**Application no:** H21-0523-09

**Description:** Erect detached double garage

**Amendment:** Amended location of garage (dwg. no. 093/02B)

Re ; Proposed double garage 33 Kiln Drive Tydd St Mary Spalding Lincolnshire  
Reference Number : H21/0523/09

SCALE
SHOWN
DATE
JULY 2009
DRAWING No
093/02
REVISION
B

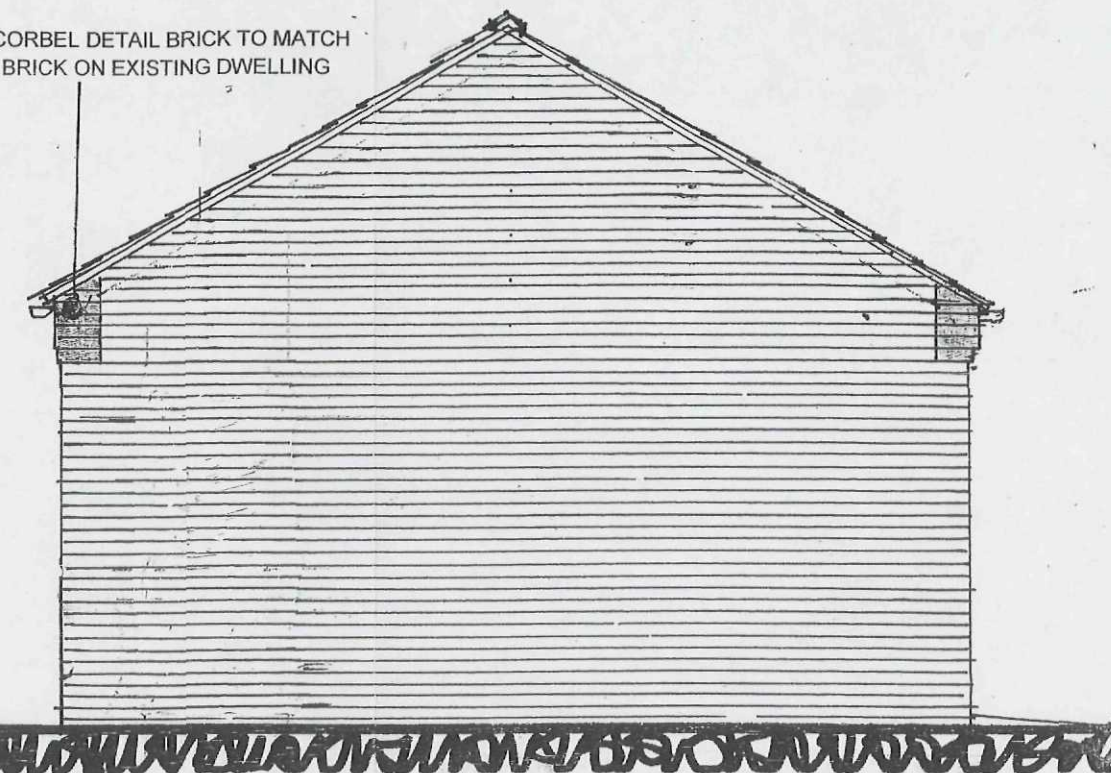
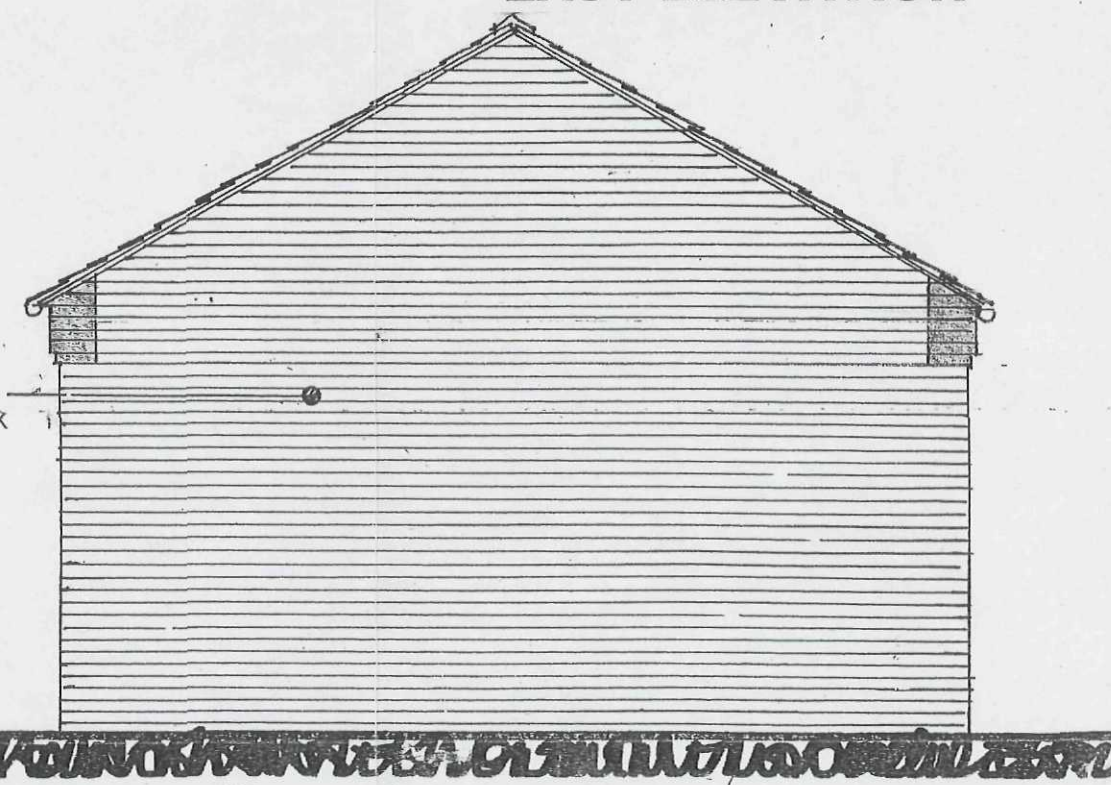
I confirm that owing to the restrictions imposed by the North Level Internal Drainage Board, it will not be possible to site the garage in the position indicated on the submitted plans. Please find enclosed three copies of drawing numbered 093/02B which shows an amended location of the proposed garage for consideration.
